Item No. **Report of the Head of Planning, Transportation and Regeneration**

Address 15 PEEL WAY HILLINGDON

Development: Erection of a single storey extension to the front and side.

LBH Ref Nos: **24498/APP/2021/4480**

PROPOSED FRONT ELEVATIONS

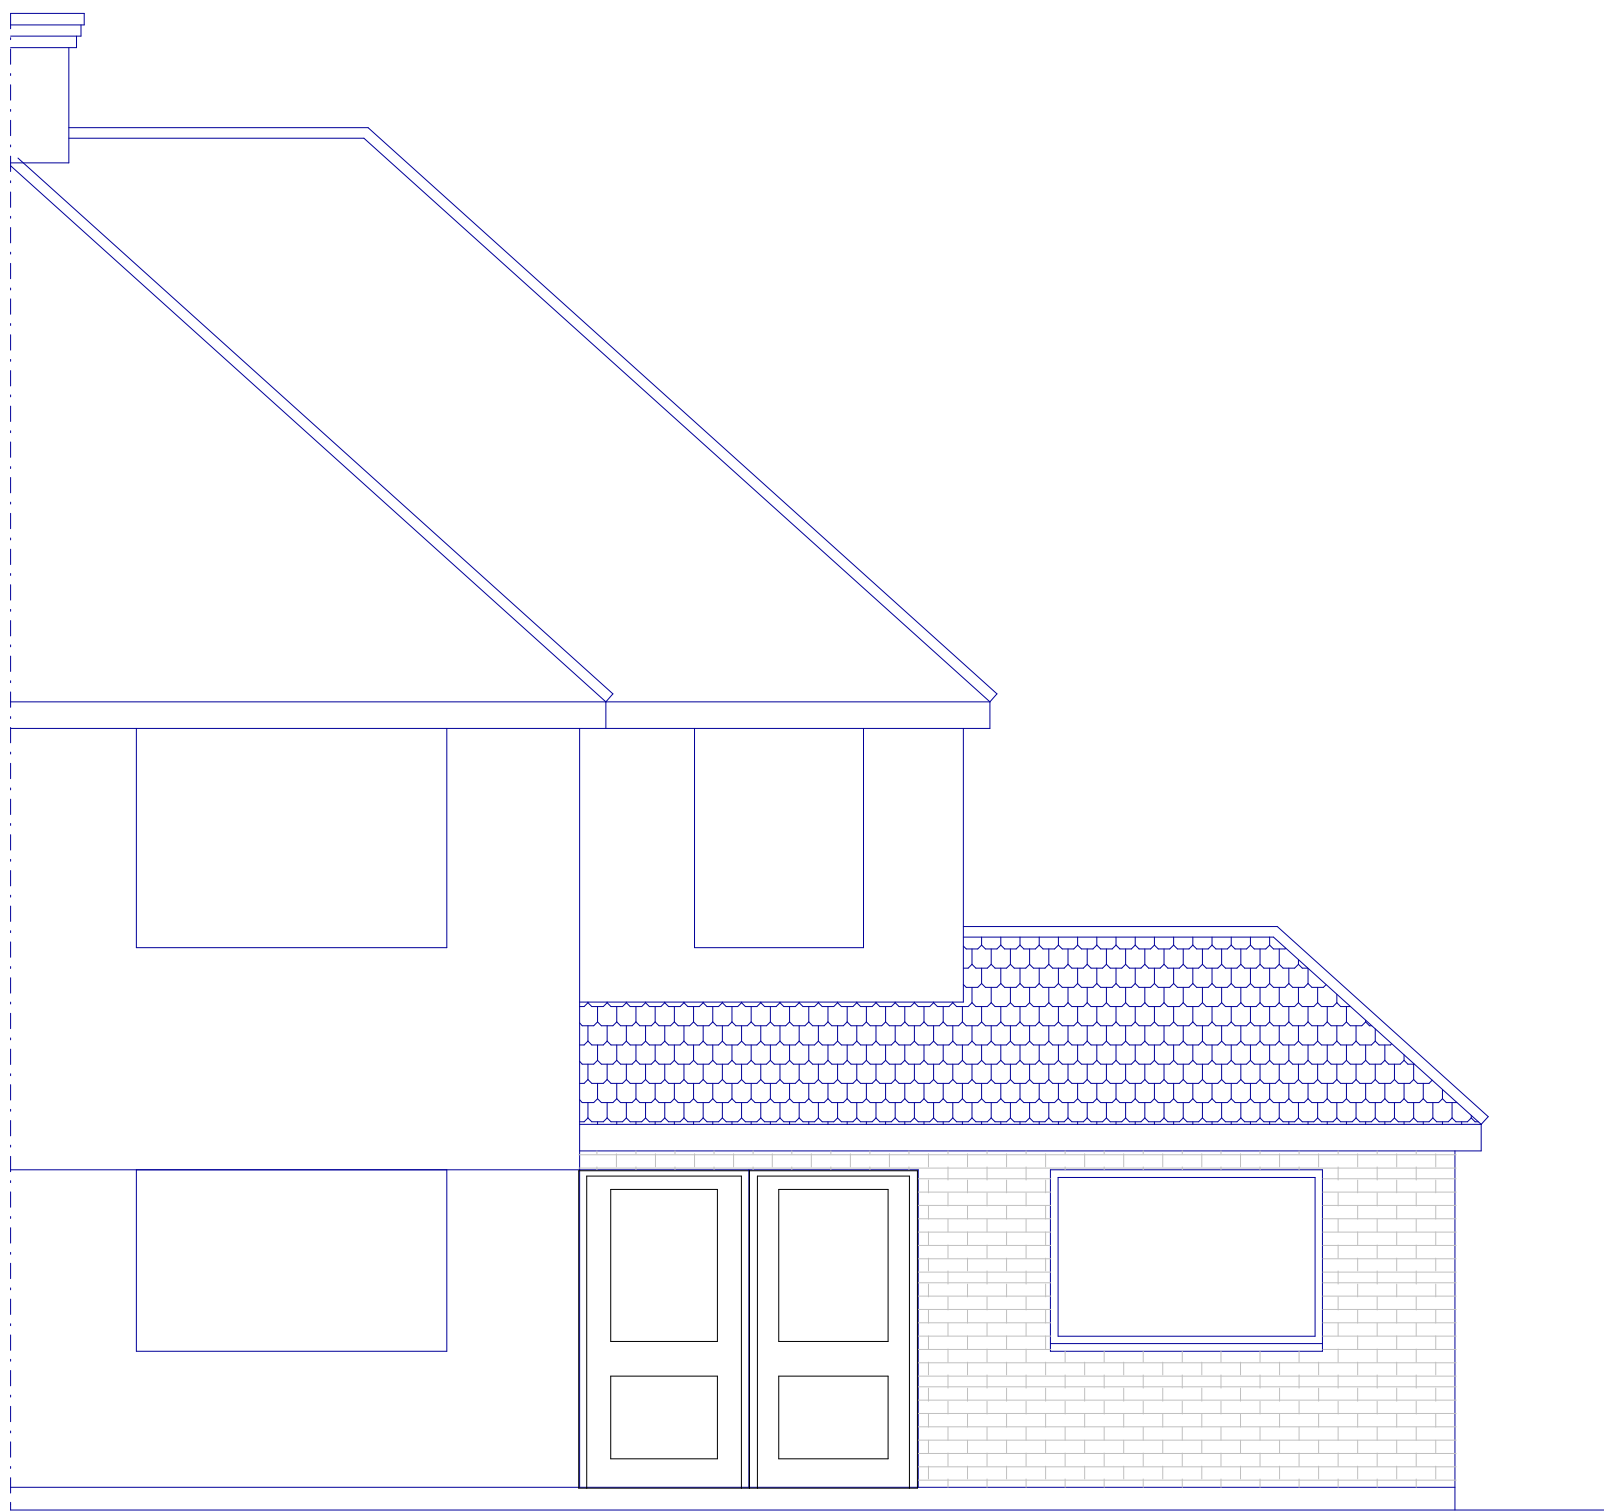
It is noted that there are no recent approved planning applications for similar schemes and the dwelling across the road and no.17 does not have a side/front extension. As a result, the extension to the front of the house would alter the overall appearance of the house and dominate the character of the street.

PROPOSED SIDE ELEVATION

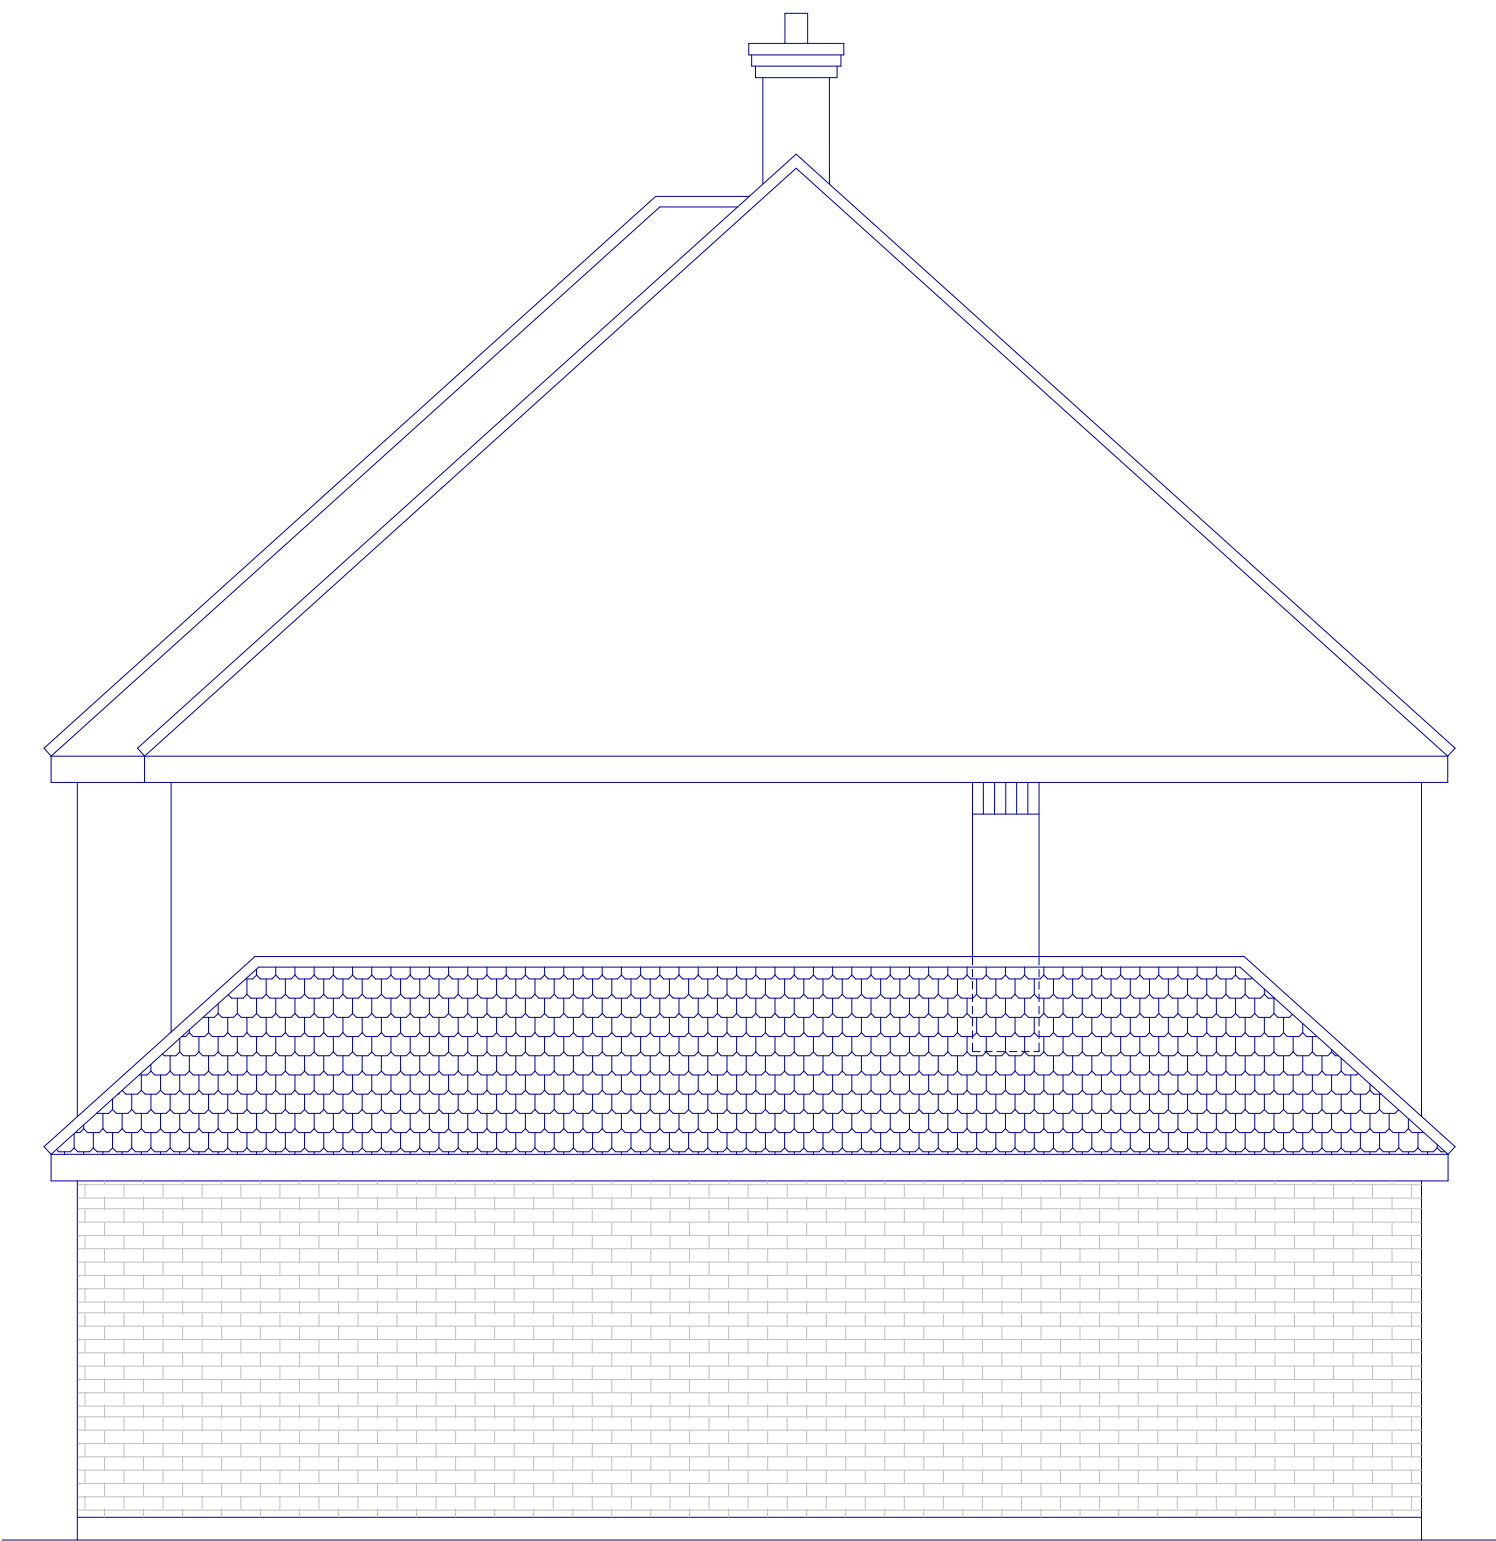
Given its dimensions, the side extension does exceed half the width of the original property, failing to comply with part i) of Policy DMHD 1 and resulting in an incongruous and insubordinate form of development.

The proposed side and front extension is set back 1 metre from the boundary, due to the openness of the corner site the breach of the building line would be very visible, as would the whole of proposed roof. Therefore the proposal would result in the loss of openness on the corner plot, resulting in a cramped appearance and would be an unsympathetic addition, representing an overdevelopment of the site, to the detriment of the visual amenities of the street scene and the character and appearance of the surrounding area. The return building line of Bradshawe Way would also be compromised, adding to the incongruous nature of the development and widening the harmful visual impact.

The proposed single storey side/front extension, by reason of its siting in a visually prominent position, size, proximity to the side boundary and projection forward of the return building line on Bradshawe Way, would result in incongruous and insubordinate form of development. Furthermore it would result in the loss of openness on the corner plot, resulting in a cramped appearance. The proposal would therefore be an unsympathetic addition and represent an overdevelopment of the site, to the detriment of the character, appearance and visual amenities of the surrounding area. The proposal would therefore be contrary to Policy BE1 of the Hillingdon Local Plan: Part One - Strategic Policies (November 2012), Policies DMHD 1, DMHB 1, DMHB 11 and DMHB 12 of the Hillingdon Local Plan Part Two - Development Management Policies (January 2020).
